Final Acceptance Punchlist

El Paso County – Department of Public Works – Stormwater Section

Project Name:	Widefield Park & Rec Improvements
EDARP File Number(s):	PPR2213, CON2261, ASB2316
ESQCP Number:	ESQ2250
Attendees:	DPW SW: Ben Jones DPW Development Services: N/A Developer: David Gish, Nuun Construction, Todd Kimes (LKA Architects), Jim Houk
Date of Walk-through:	04/08/2026
Walk-through Number:	1st

C7.4

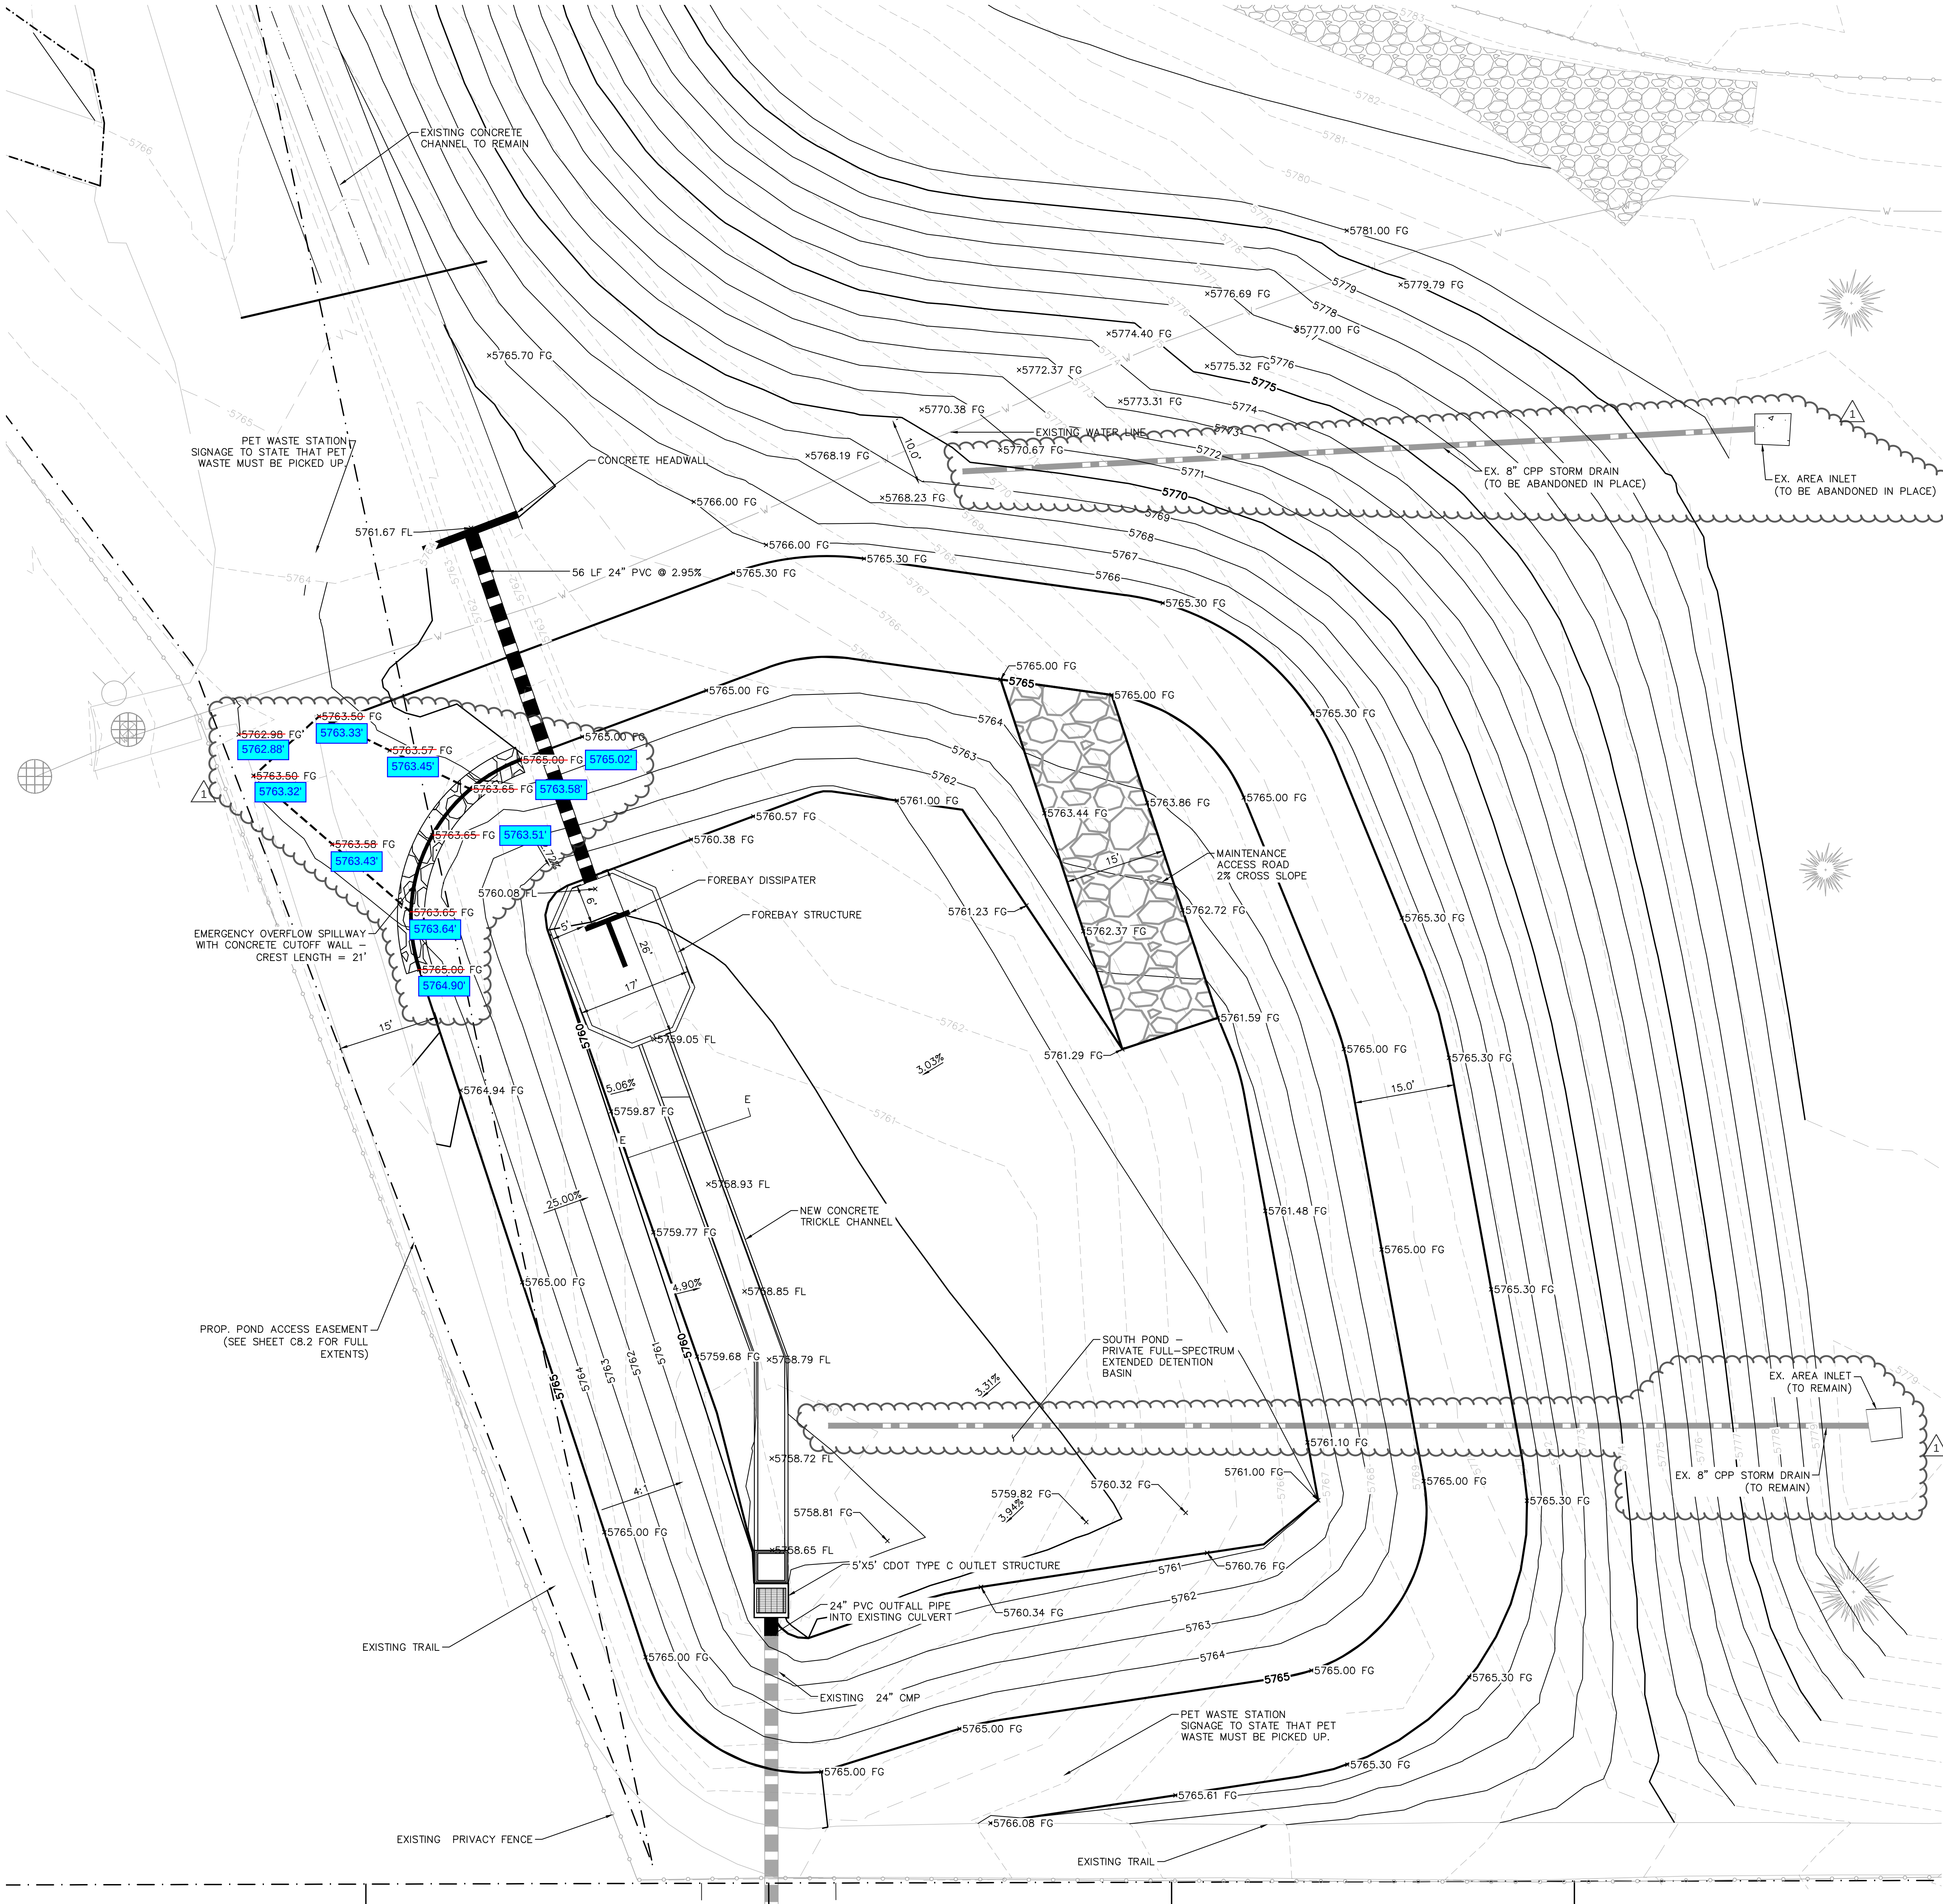
Were flows to these inlets not intended to be conveyed to and treated/detained by the pond? Please discuss in the pond cert letter.

- Elevation of Emergency Spillway, show on as built.
- Area drains
 - 2 Inlet drains. South side above pond, show on as built.

KHA Response: North area drain is filled with sediment and non-functional. North drain and associated pipe are to be abandoned in place. South area drain and pipe is functioning and will remain. A revision of the CD Sheet C7.4 (Pond Grading) has been reprinted showing these pipes for documentation purposes.

KHA Response: Emergency spillway grading as-built marked up on revision of the CD Sheet C7.4 (Pond Grading).
